Subject: RE: Planning Consultation on: BE/53/22/DOC

Application No: BE/53/22/DOC
Registered: 26th May 2022
Site Address: Unit 9 Salt Box Field Land off Rowan Way Bersted PO22 9NW
Description of Works: Approval of details reserved by condition imposed under BE/135/18/PL relating to conditions (Full Application) 14-Maintenance and Management of Surface water drainage, 37-details of all fixed plant, machinery and equipment associated with air moving equipment & 42- details of PVs

Unit 9 Salt Box Field Land off Rowan Way Bersted PO22 9NW

Planning Reference: BE/53/22/DOC

PROJECT / ORIGINATOR / ZONE / LEVEL / TYPE / PROJECT NO.
114378-CAL-XX-XX-DR-D-0500

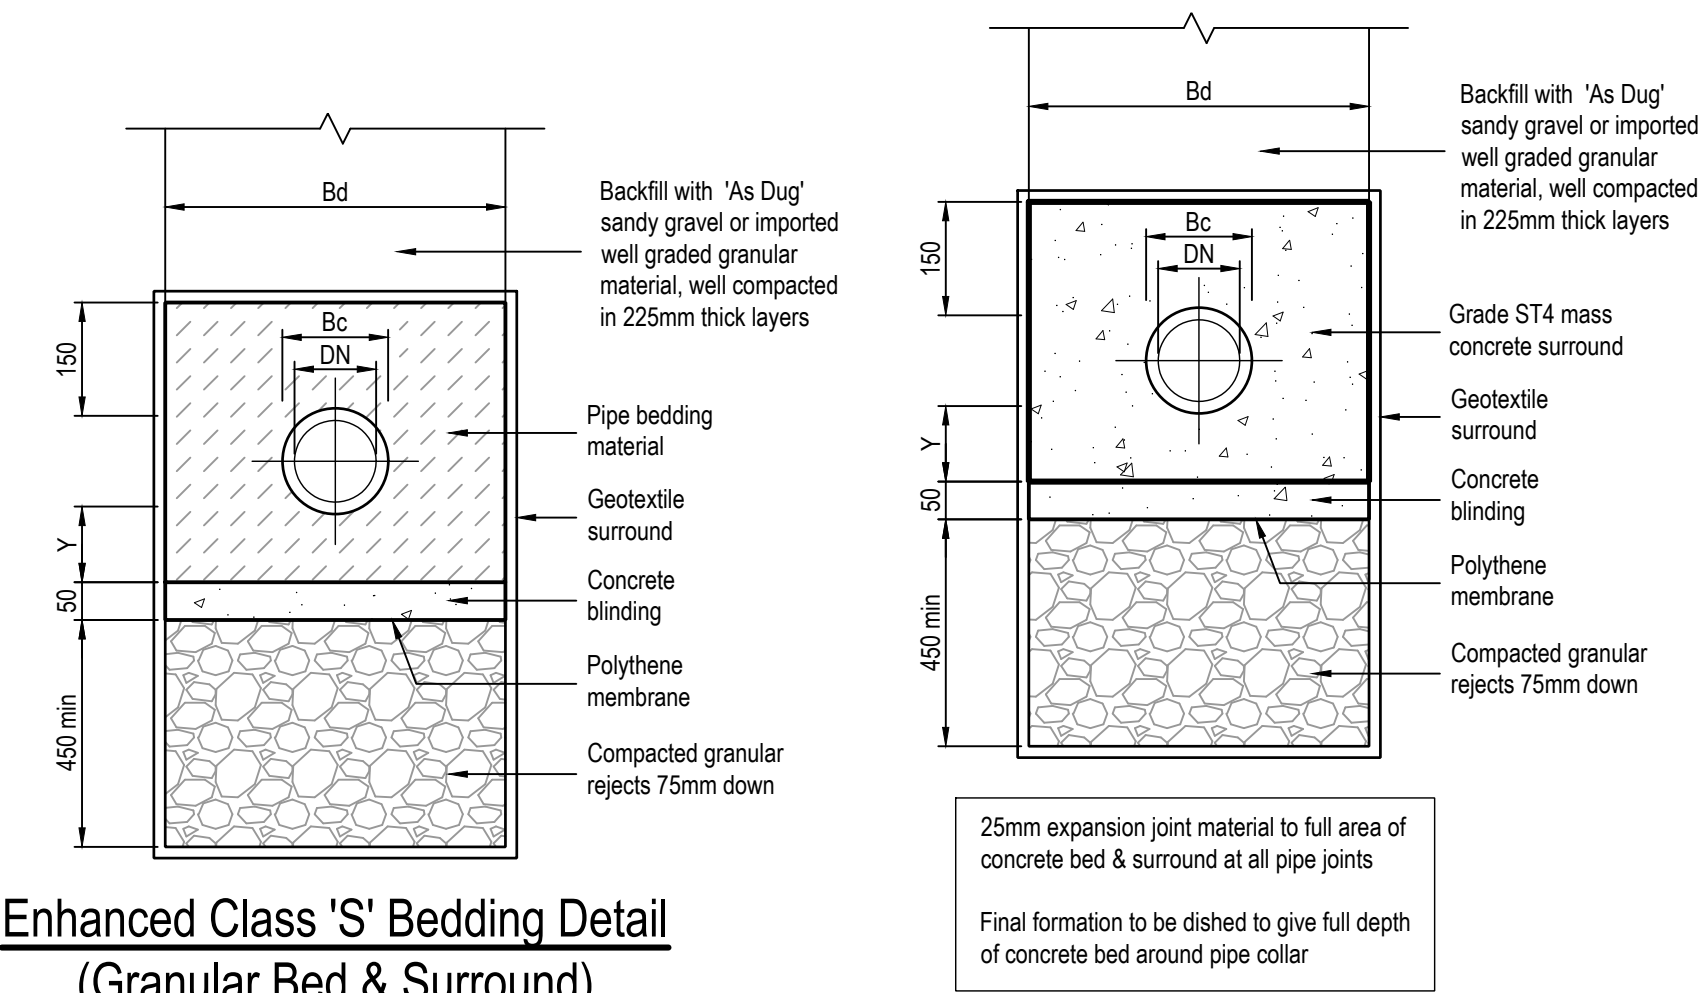
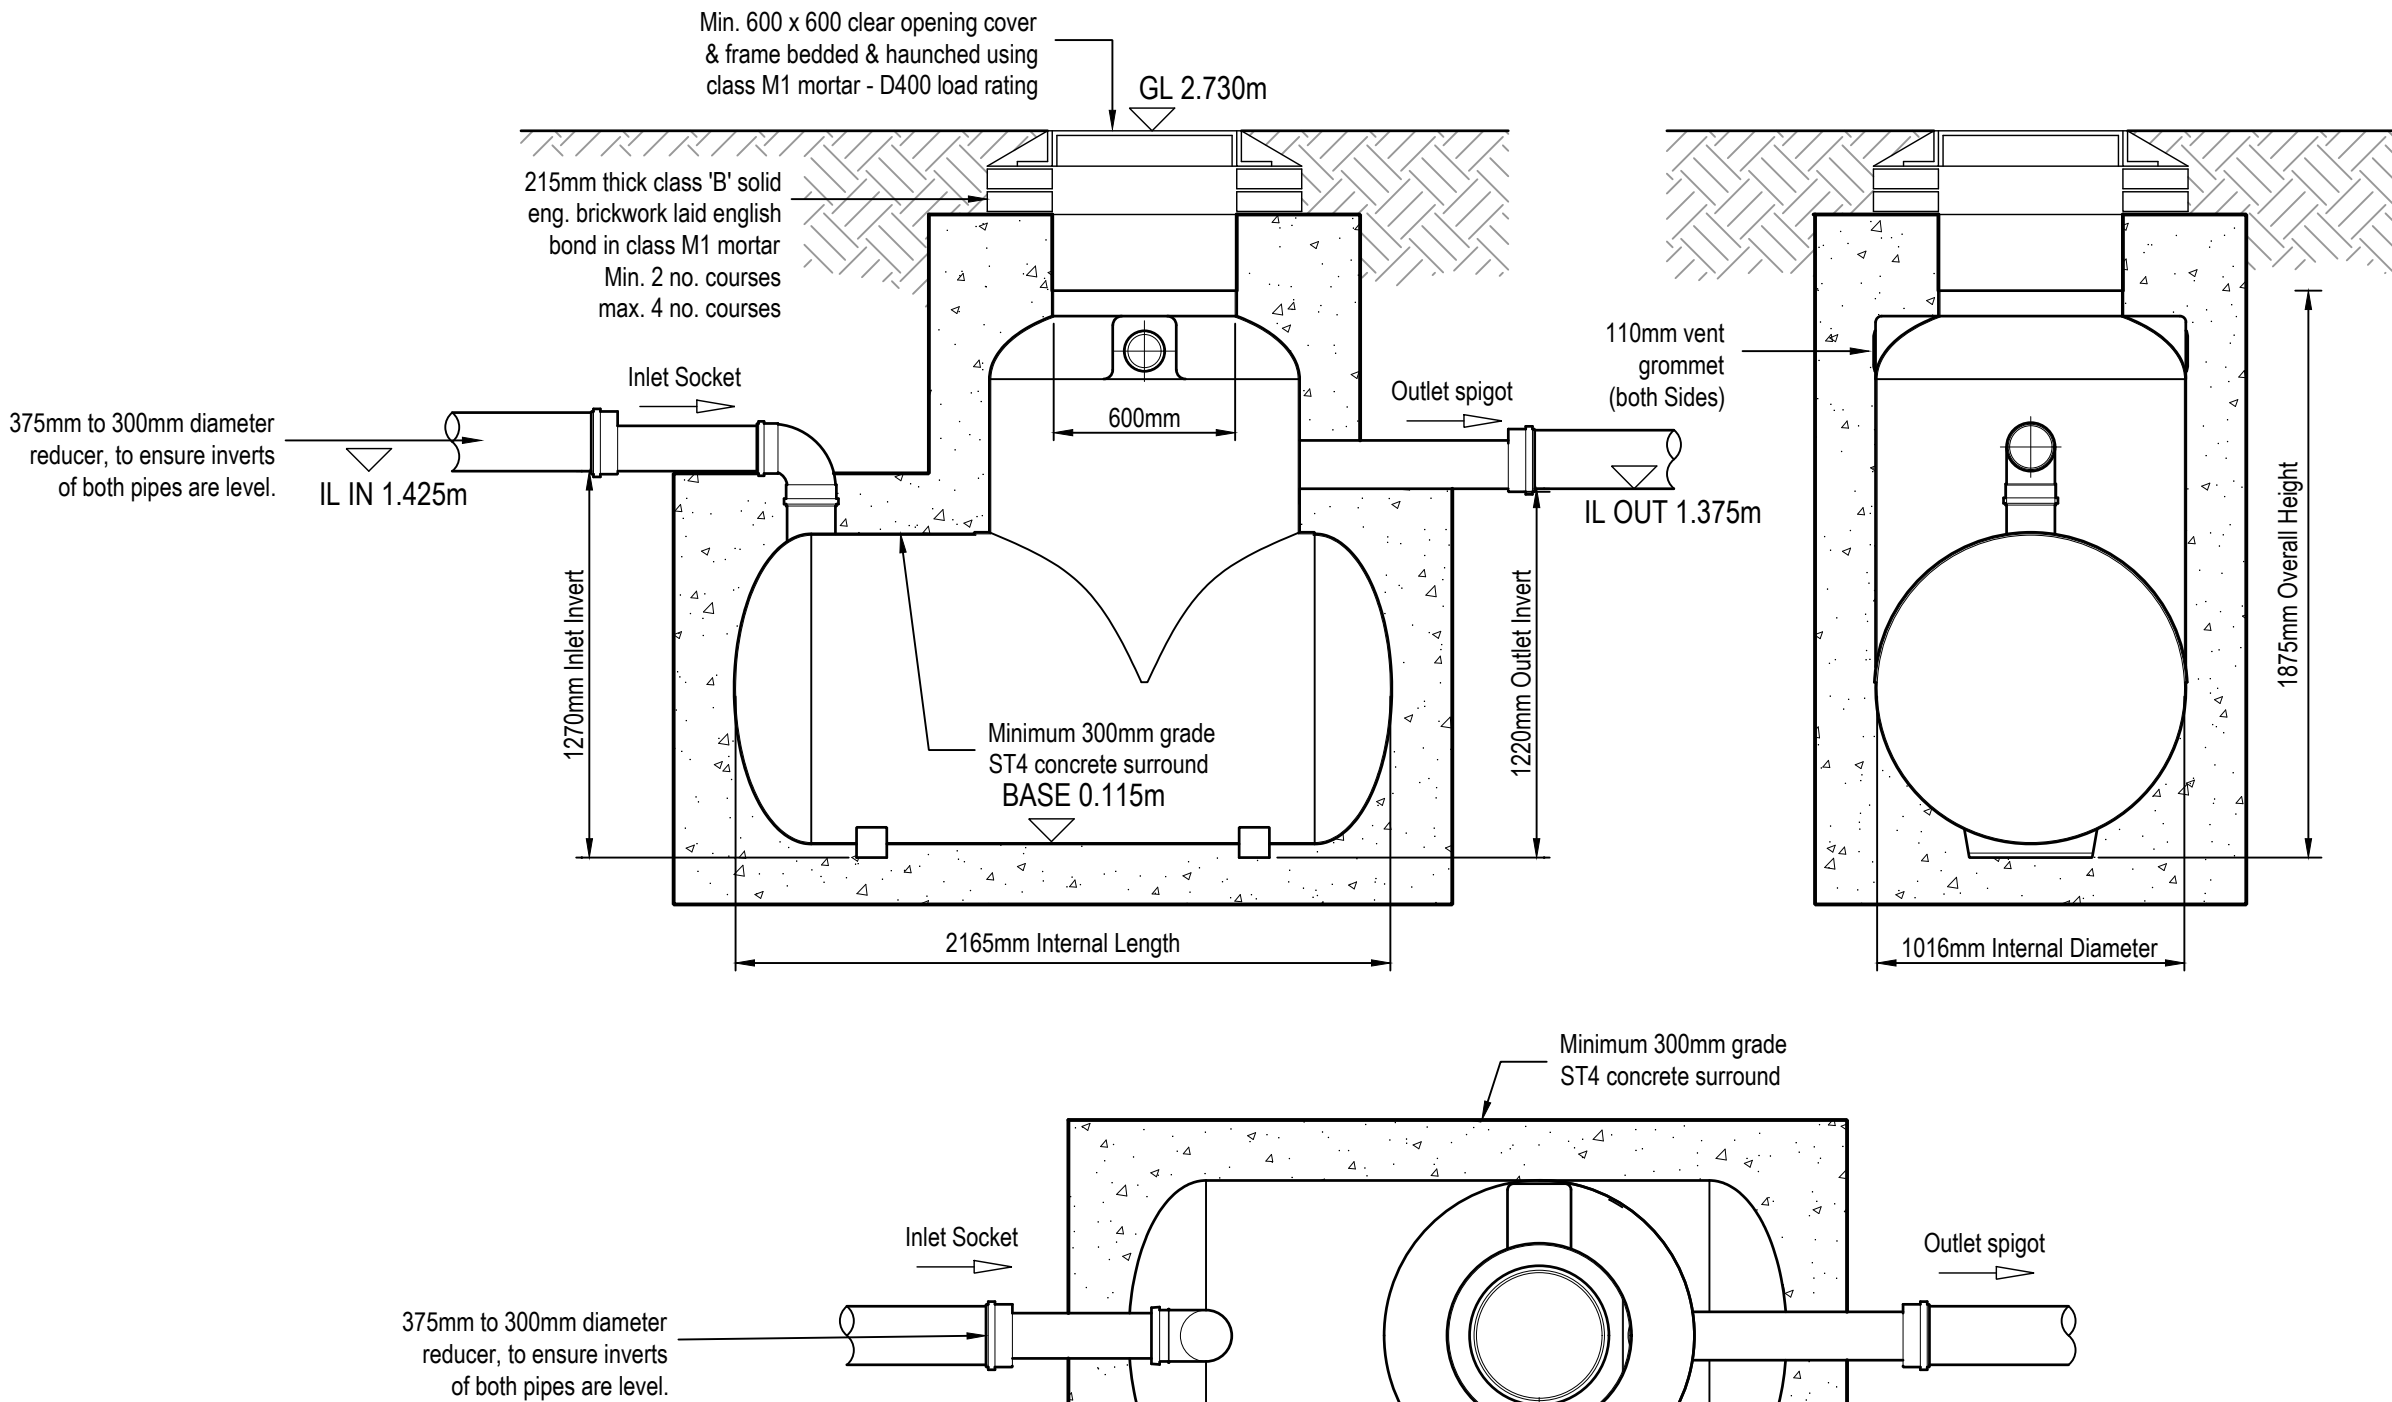
The typical construction detail of the washdown and silt separator on drawing 114378-CAL-XX-XX-DR-D-0503-C is unacceptable. The construction detail should be provided for the actual separator being specified and clearly indicate invert levels of pipe connections and cover levels updated comments 16/12/22 – The updated report now contains this information on the updated drawing 114378-CAL-XX-XX-DR-D-0503-D and this addresses our comments and now acceptable

Construction Details of the washdown silt box needs to be provided- updated comments 16/12/22 – this information is still outstanding, please provide

Hydrobrake Manhole in Tubosider Tank
Construction Detail

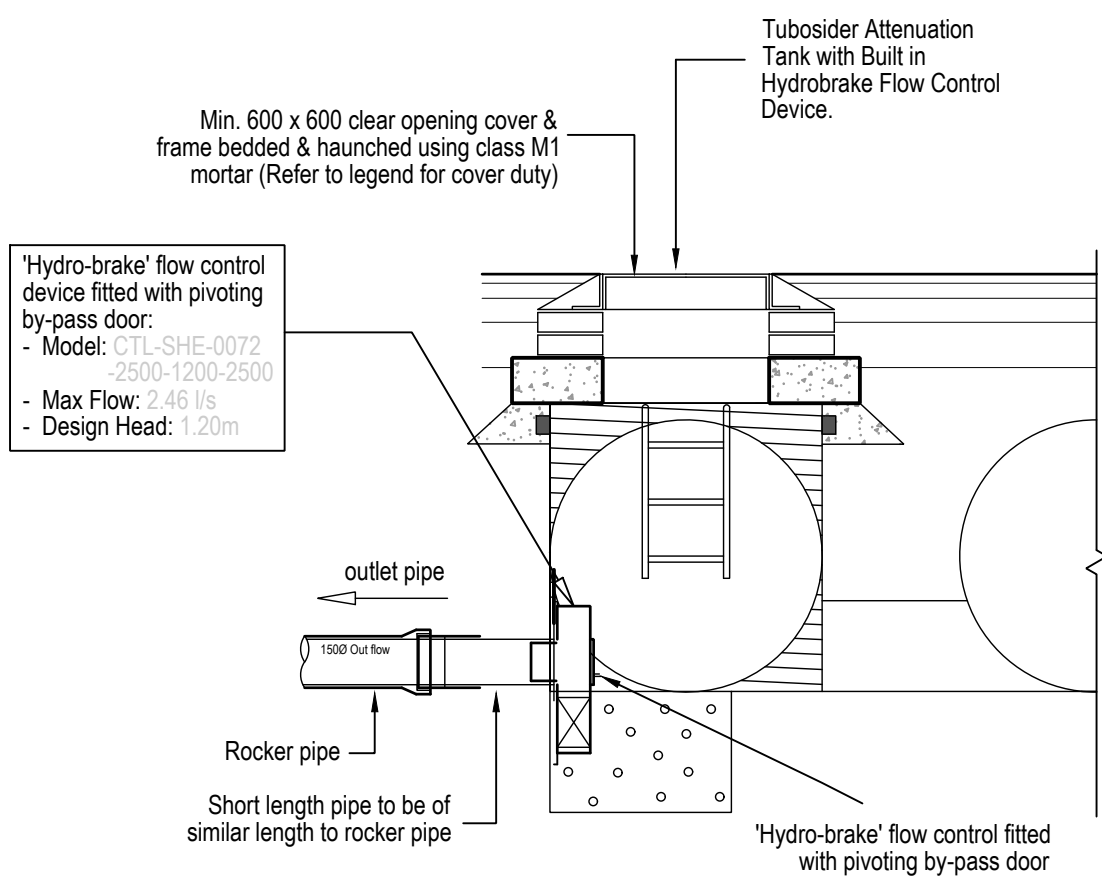
A construction detail on the Hydrobrake manhole needs to be provided and showing clearly how it ties into the proprietary attenuation system, this is important to ensure that future maintenance requirements within this manhole is clear- updated comments 16/12/22 – this information is still outstanding, please provide.
